**Consultation Response from KC,
Trees**
2025/90207 23, Oldroyd Way, Dewsbury, WF13 2JJ
Erection of single storey side extension
Date Responded: 07/02/2025
Responding Officer: Hazel Irving
Responding Ref: 06/92

It is understood that the application is to construct a single-storey side extension, within the area of an area TPO 06/92.

02 Proposed Site Plan
Scale 1:200 @ A2

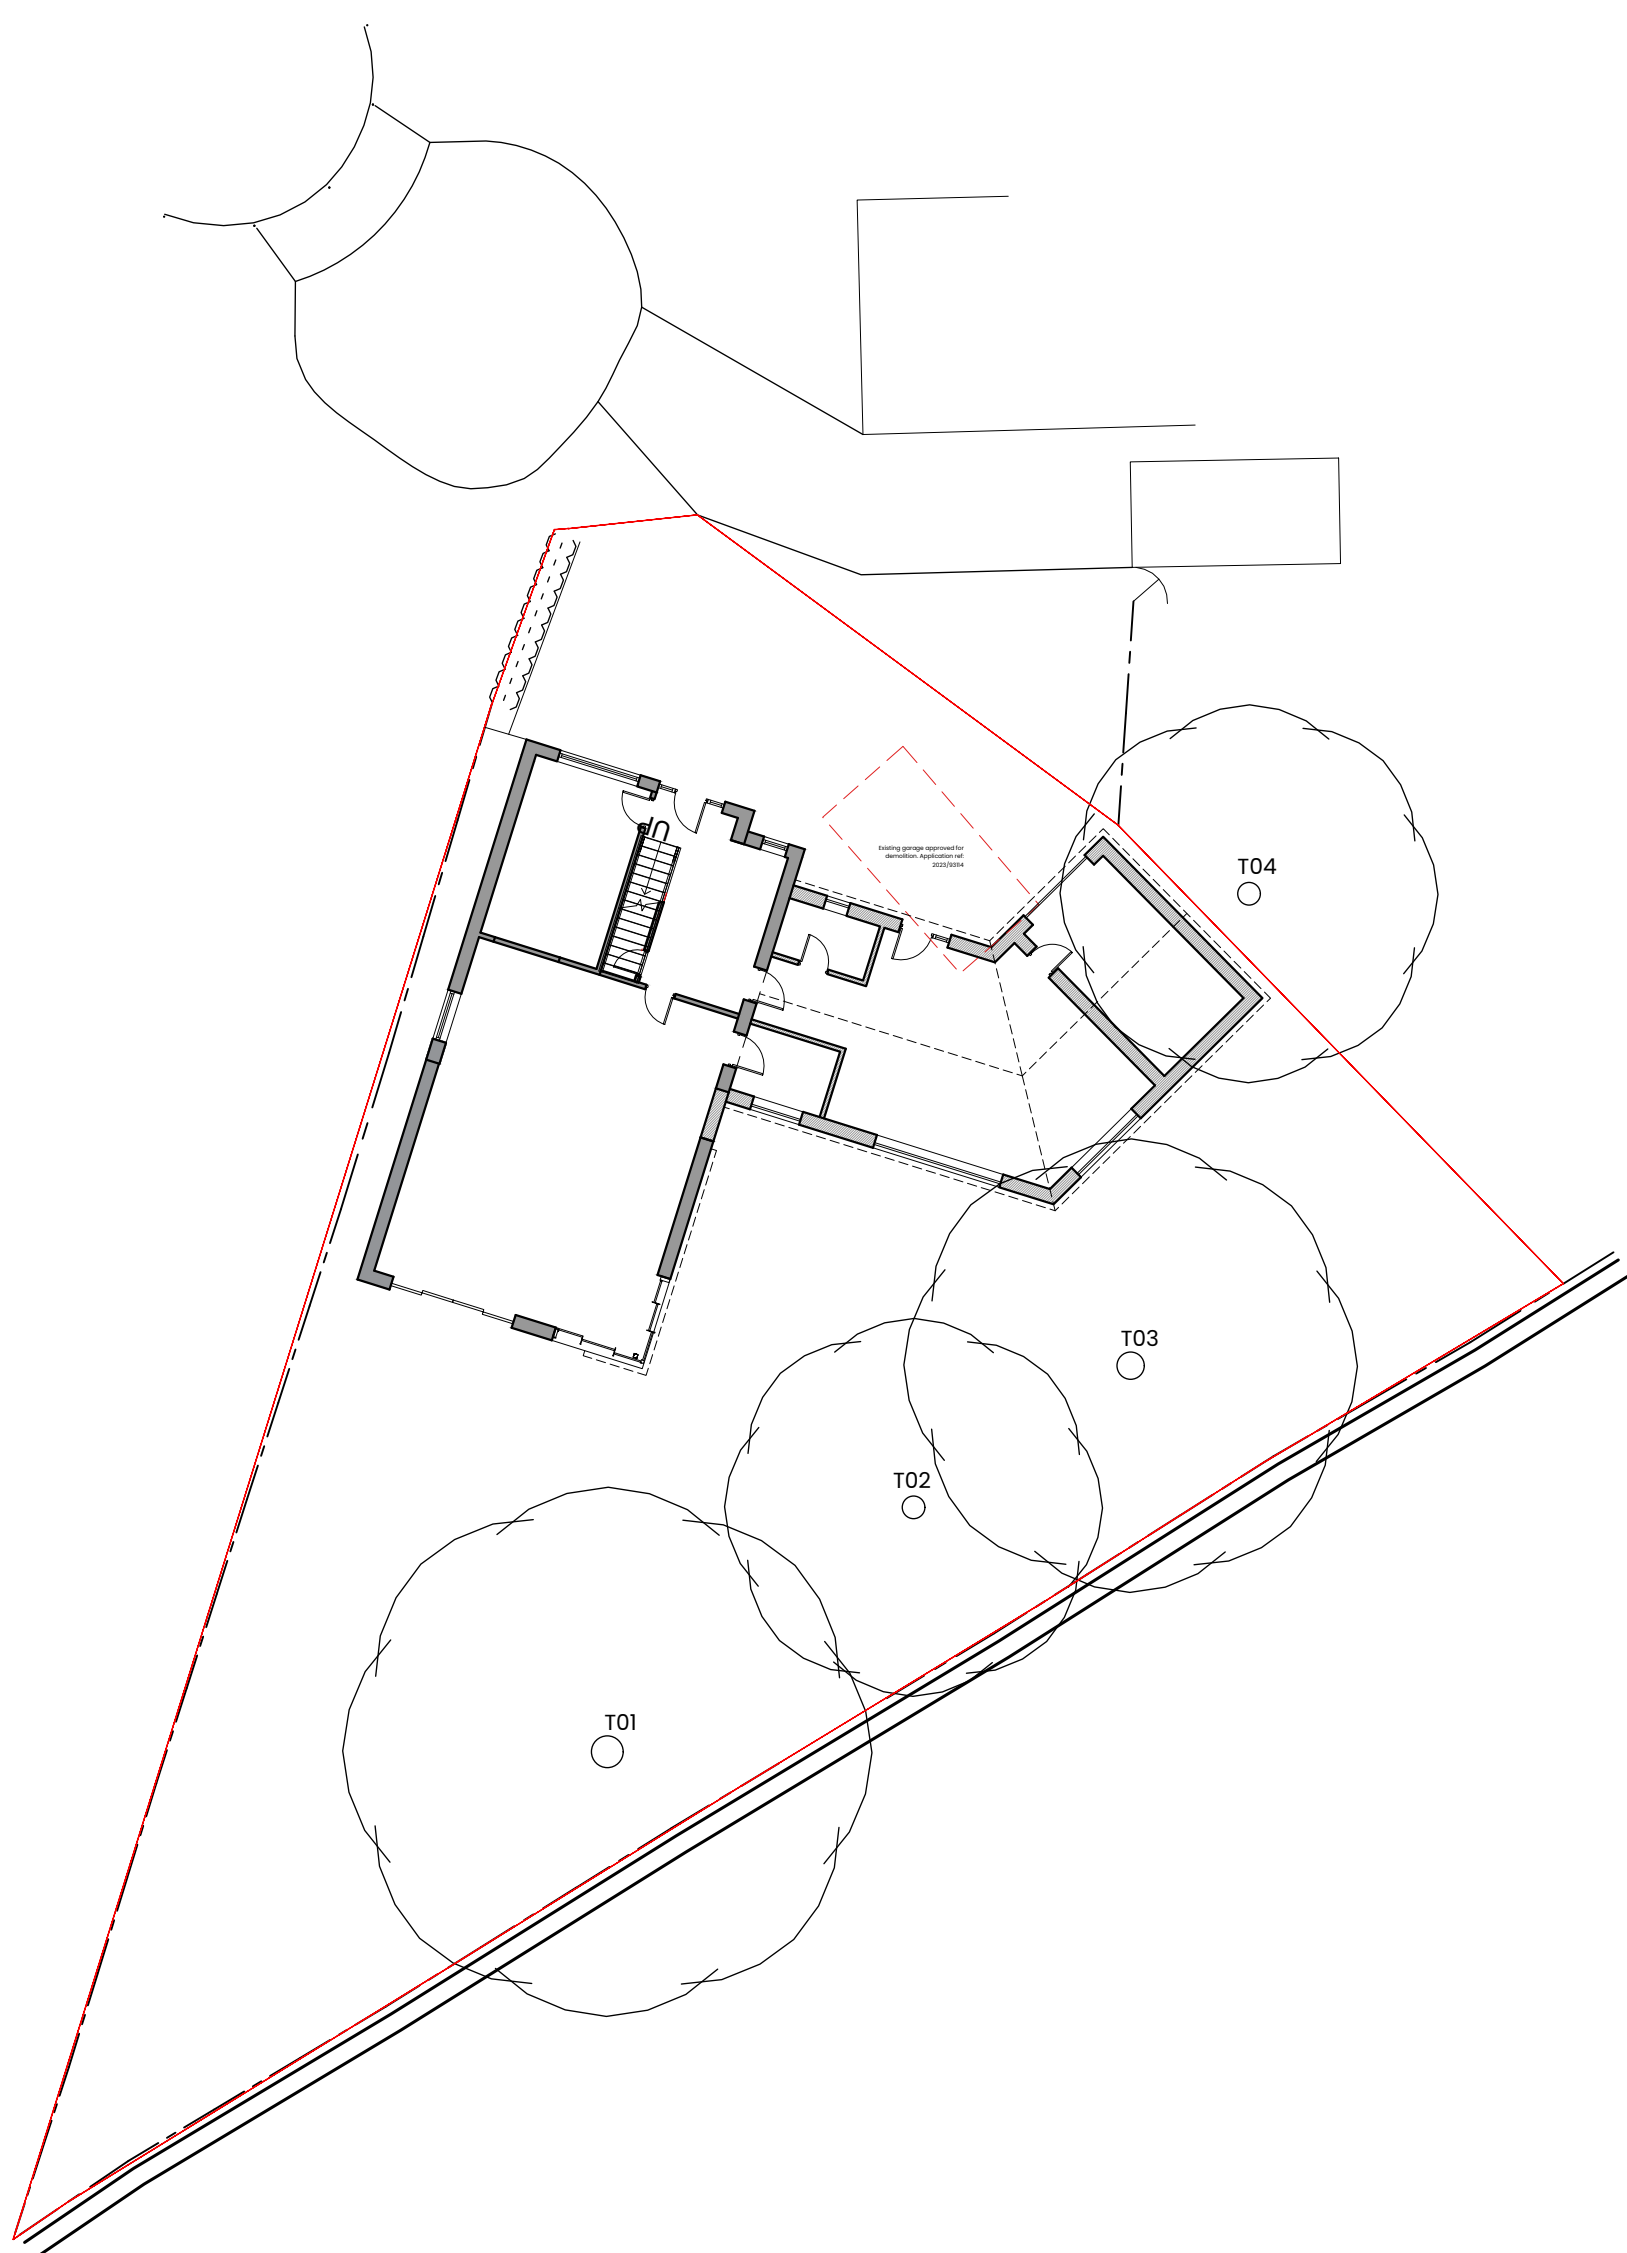
- The extension is proposed to be constructed within approximately 50% of the RPA of T4 and a significant portion of the RPA of T3. The building would impact surface water availability to a significant portion of the rooting systems of these trees. This could negatively impact the health of these protected trees, as they adapt to the change in their rooting environment.

- The proposed extension extends to within approximately 1m of the stem of T4, where there will be large, structural roots, essential for maintaining the stability of the tree. There is the possibility that large, structural roots could be impacted if piling was to be carried out in this location, as invasive hand augering is proposed to locate root-free positions for the piles. This method of locating roots could result in accidental damage.

- The proposed extension is proposed to be constructed within the canopy line of the trees; therefore, the building would be under the canopy once constructed. This would cause pressure to crown lift or even remove the trees as they overhang the roof, shading it from the sun and trapping humid air close to the building, creating potential for damp conditions.

- The trees have not yet reached their final size and can grow significantly larger. For example, T4 is a lime and T3 is a sycamore, these trees typically grow to heights of 20m-30m, with crown spreads of 10m-15m in radius. In time the entire extension would be under the canopies of T3 and T4.

- T4 is not within the ownership of the applicant and would be the most impacted by the proposals (off-site at No. 10 Oldroyd Way).
